**Notification of Modification Request for Four Points by Sheraton Hotel Expansion
(SSD 4972 MOD 7)**

Thank you for your correspondence dated 7 February 2019, requesting Transport for NSW (TfNSW) review and comment on the above.

Drawing Title
WHEAT ROAD
BUS BAY TURNING PATHS
1 OF 2

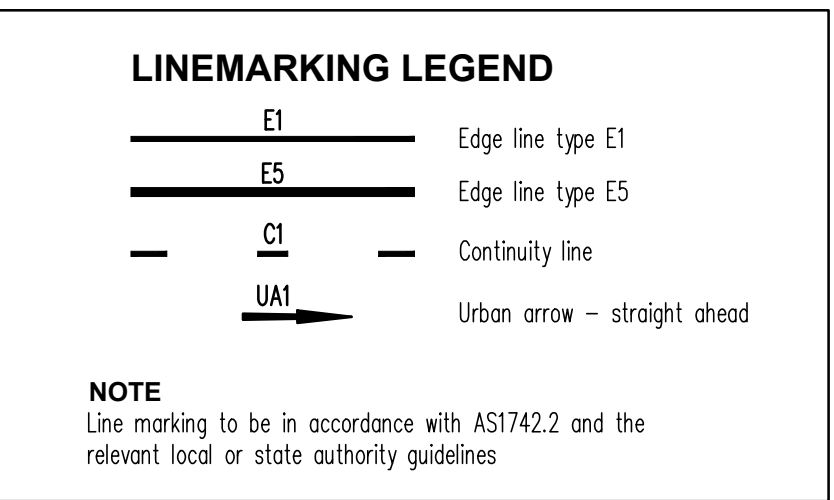
TfNSW notes that the proposed modification would provide fewer coach parking spaces than the parking facility approved for the State Significant Development. TfNSW advises that there is high demand for coach parking within the CBD and requests that the applicant:

- Consults with the Sydney Coordination Office within TfNSW and BusNSW, prior to the preparation of the applicant's Response to Submissions; and
- Considers the advice provided during the consultation and amends the design to provide more coach parking spaces and to address any safety issues.
